# Outer Dowsing Offshore Wind

## Submission Documents Summary and Change Log

Document Reference: 27.4  
Rev: 1.0

Figure 4.2: Map showing the ANS areas to the north-west and south-east of the array area (coloured purple).

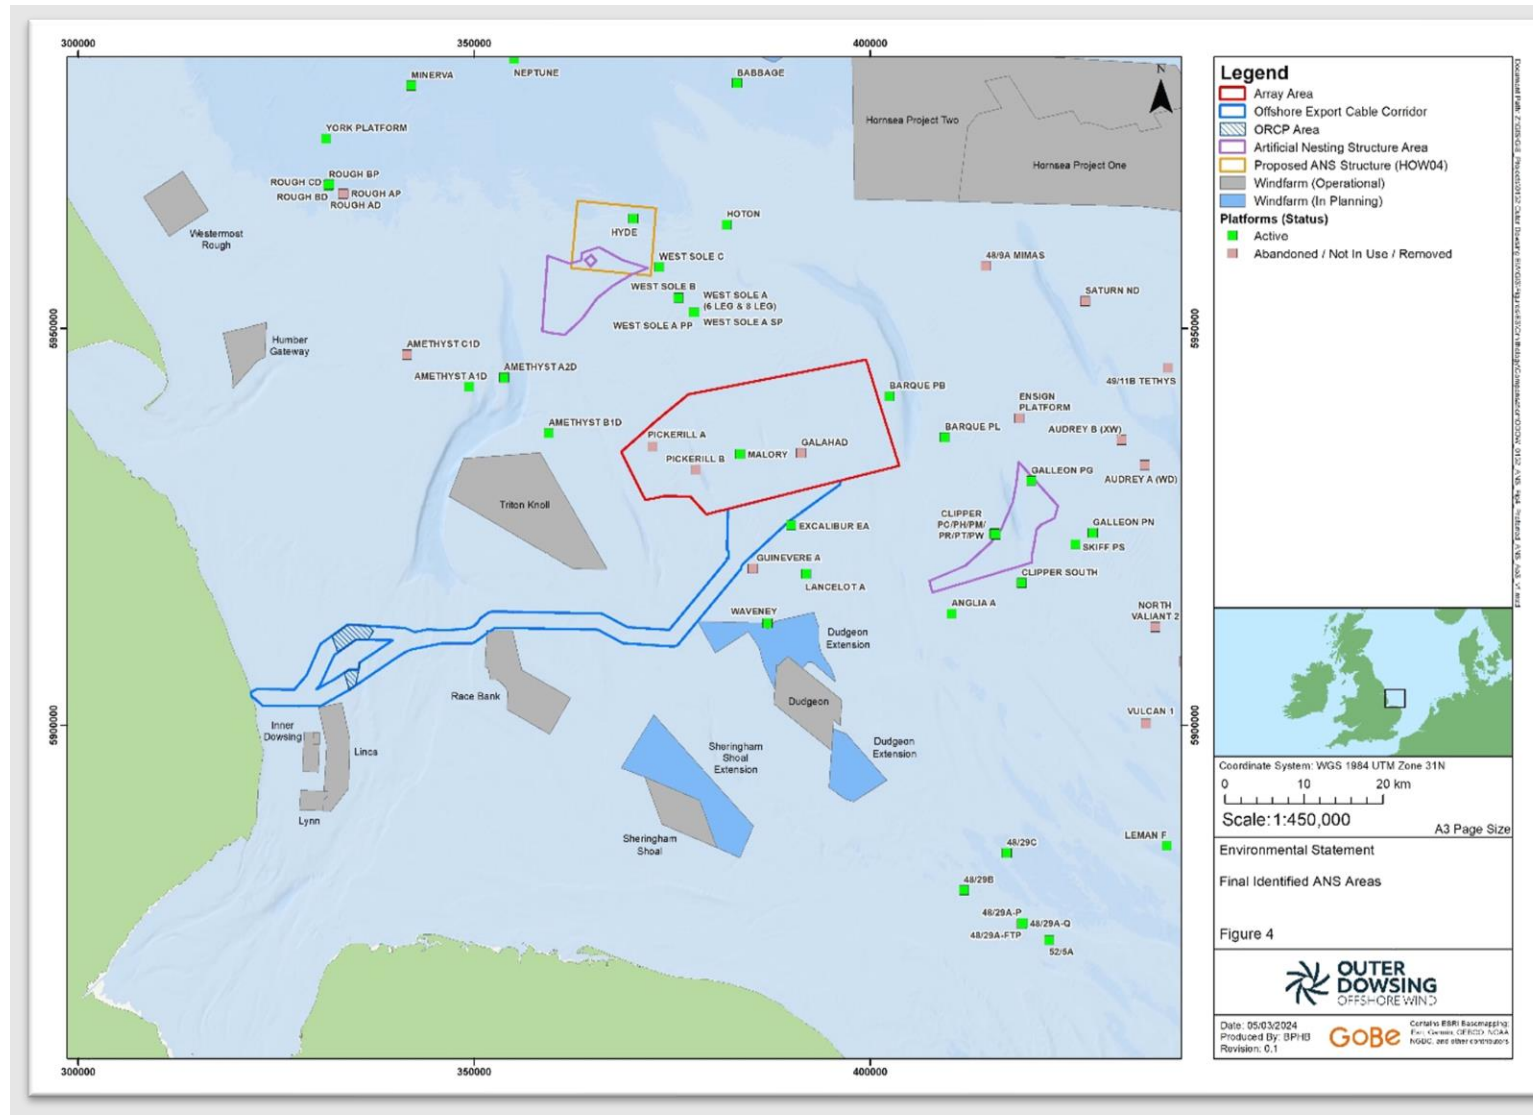
Document Reference	Document Title	Changes	Relevant paragraph in SoS letter
	Evidence Base and Roadmap	<p>The Applicant has reviewed the colony details of FFC SPA provided within Offshore Artificial Nesting Structures Evidence Base and Roadmap (document reference 7.7.4, v4 submitted 9 September) and confirms that they are aligned with the most recent data available via the SMP website (BTO, 2025).</p> <p>In addition, the document has been updated to add clarity to the nesting density calculation where necessary.</p>	<p>number of pairs of Guillemot per nesting unit.</p> <p>Paragraph 29 of the Secretary of State’s Letter relating to FFC SPA colony counts.</p> <p>Paragraph 31 of the Secretary of State’s Letter relating to discrepancies in ornithology documents.</p>

Figure 1: [Habitat suitability for \*Sabellaria spinulosa\* reef within the Outer Dowsing Offshore Windfarm Export Cable Corridor \(ECC\) and Inner Dowsing, Race Bank and North Ridge Special Area of Conservation \(IDRBNR SAC\).](#)

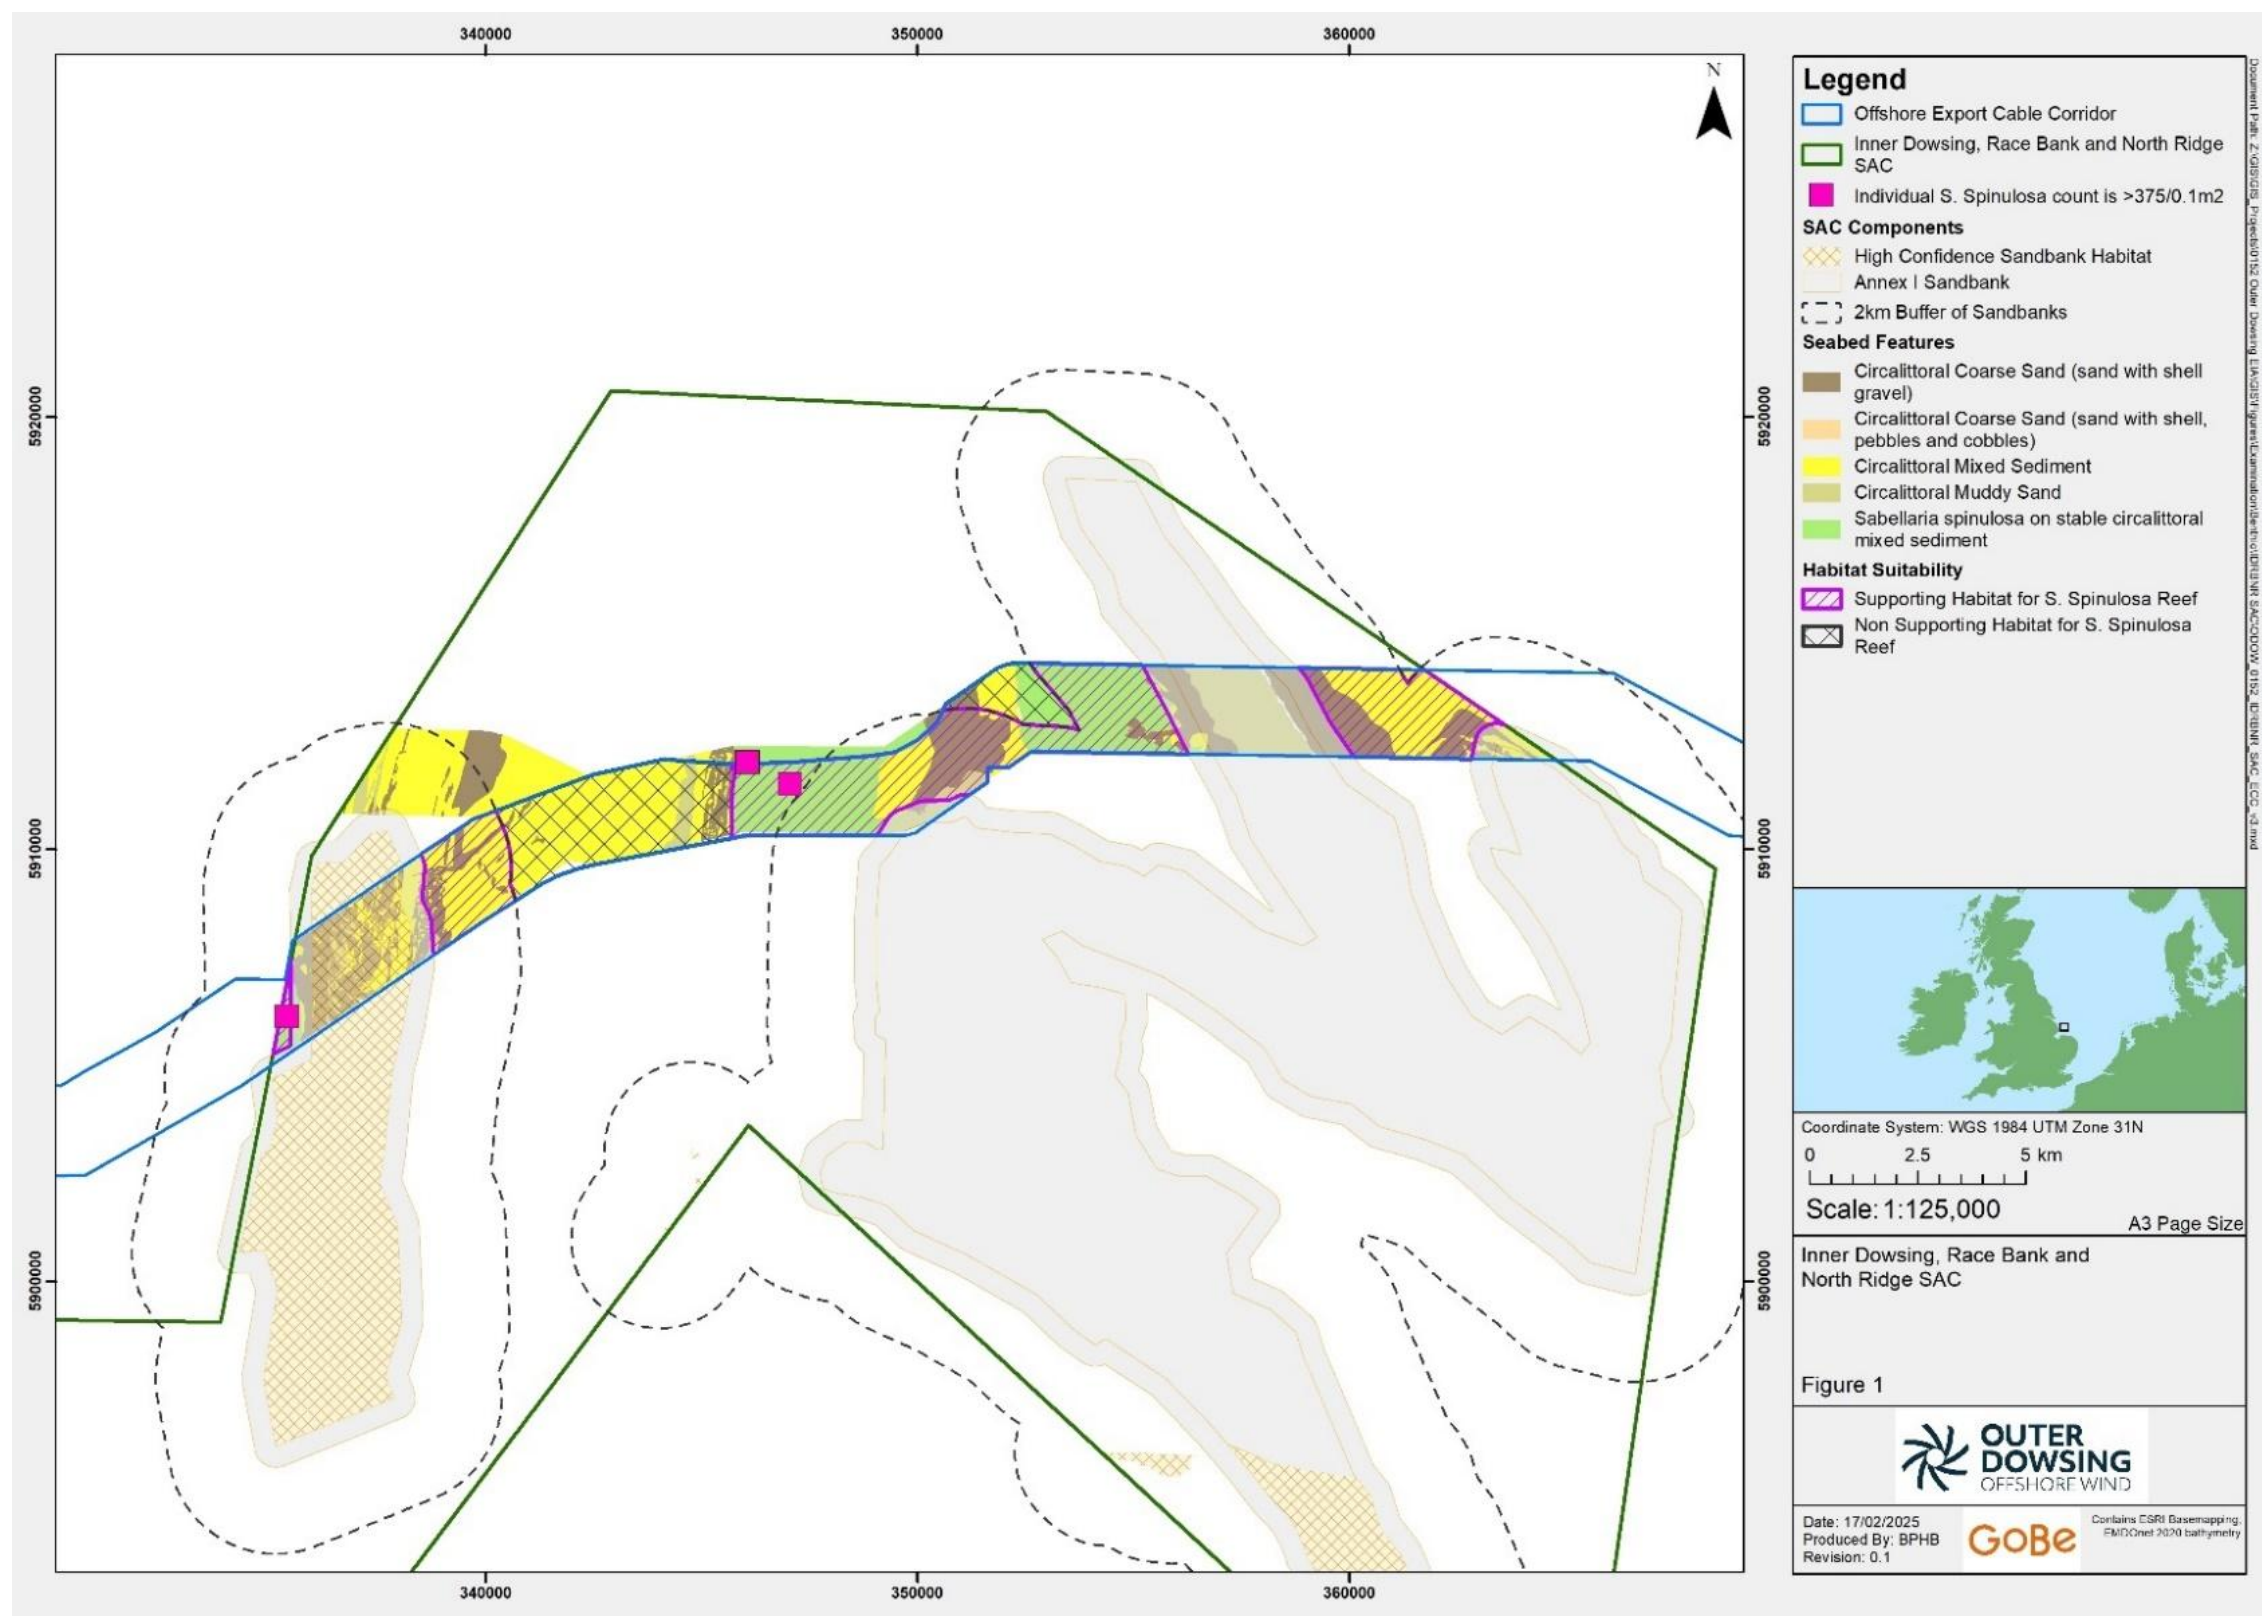
8.21	Outline Scour Protection and Cable Protection Management Plan	<p>The Outline Scour Protection and Cable Protection Management Plan has been updated to include the commitment that nearshore cable protection will not exceed 0.35m.</p> <p>It has also been updated to reflect changes made following discussions on the same matter with Natural England (details of Natural England’s advice is provided in Appendix B in 27.2 The Applicant’s Response to the Request for Information).</p>	Paragraph 8 of the Secretary of State’s Letter, requesting the Applicant commit to the nearshore cable protection not exceeding 0.35m.
